Addendum No. 1

RE: Contract # C204488

BRIDGE #190009 AND #190010 OVER NOTTELY RIVER AND GRAVEL RD ON
US-64 & US-74.

The following revisions have been made to the Traffic Management Plans.

TRANSPORTATION MANAGEMENT PLAN
CHEROKEE COUNTY

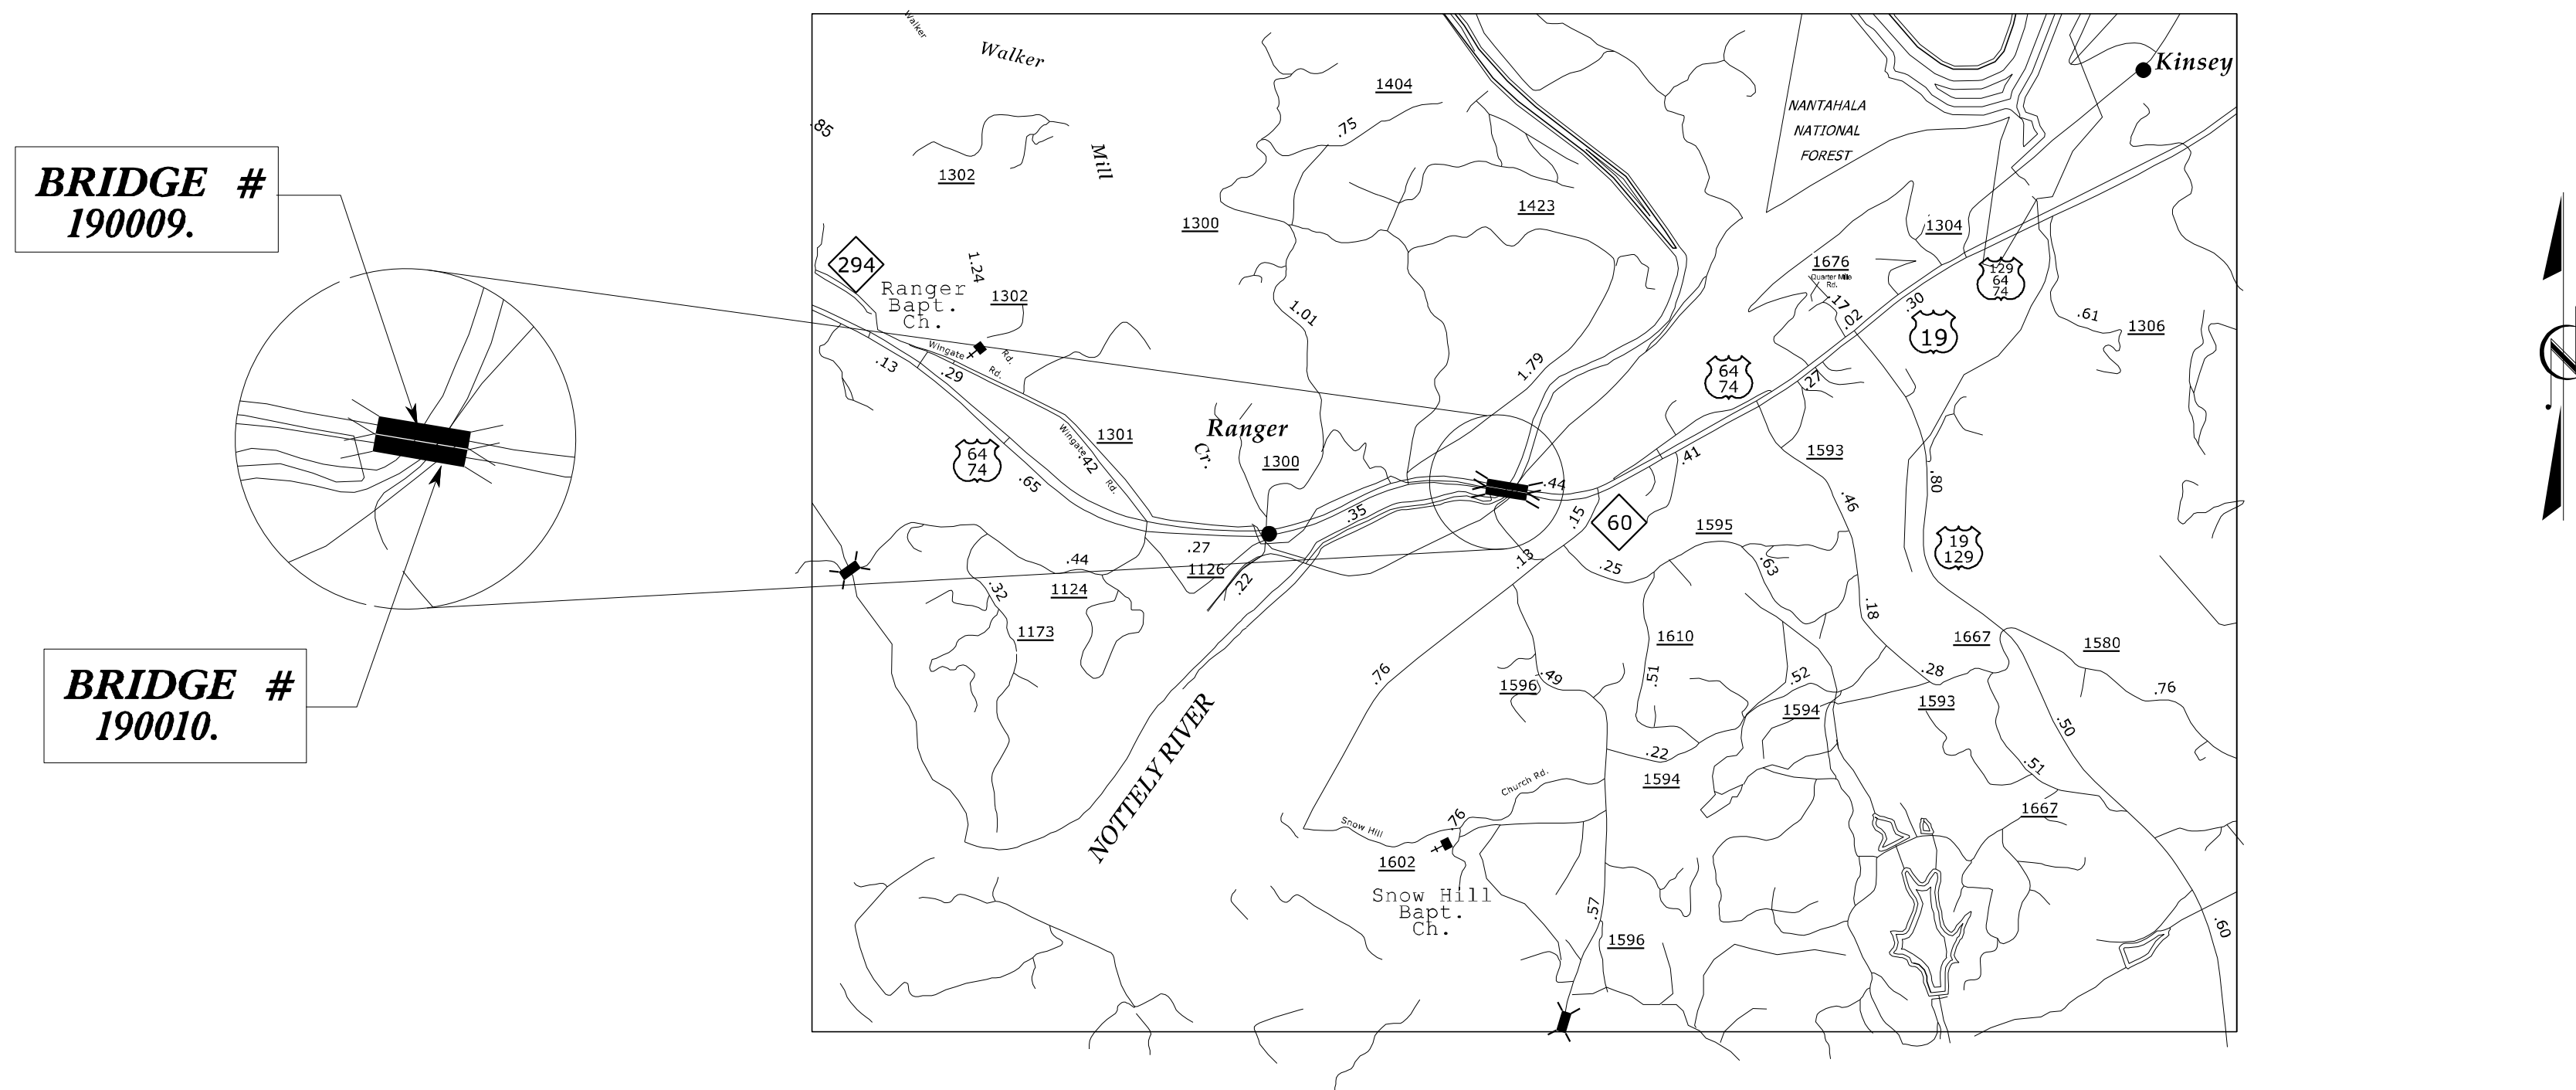
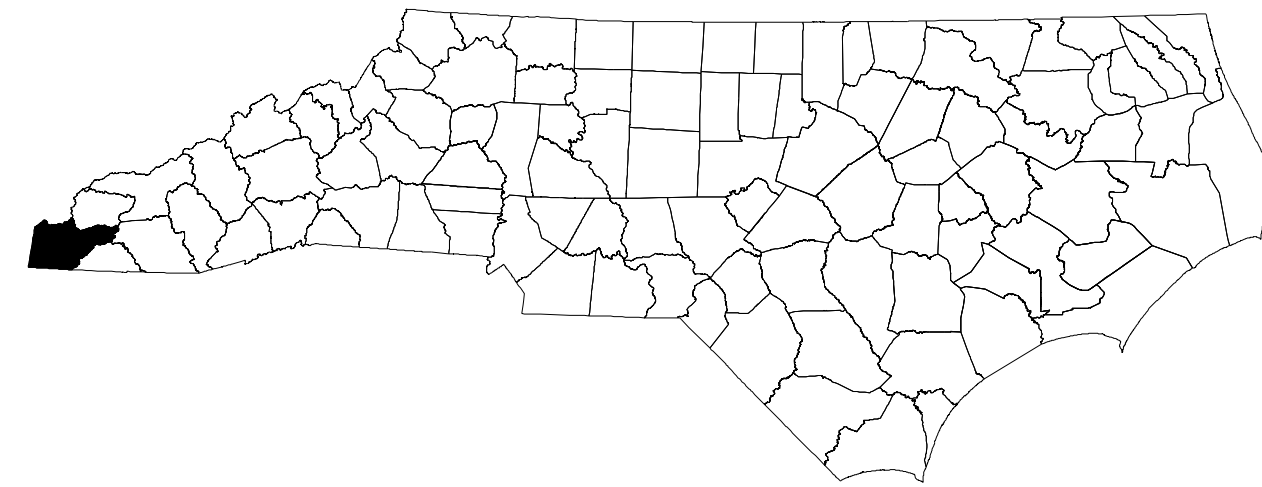
Sheet No.	Revision
TMP-1	Index of Sheets updated.
TMP-1B	Note "I" was added in addition to PCB notes and Time Restriction changes.
TMP-1C (New)	Phasing was re-written to include the 15-day lane closure ICT (per lane), for the bridge work.
TMP-2	Typical Sections to include the barrier for the long-term lane closure.
TMP-3	Plan View to show the new traffic setup for the long-term lane closure, to include, but is not limited to stationary signs, PCB (anchored), crash cushion, temp PM, drums, etc.
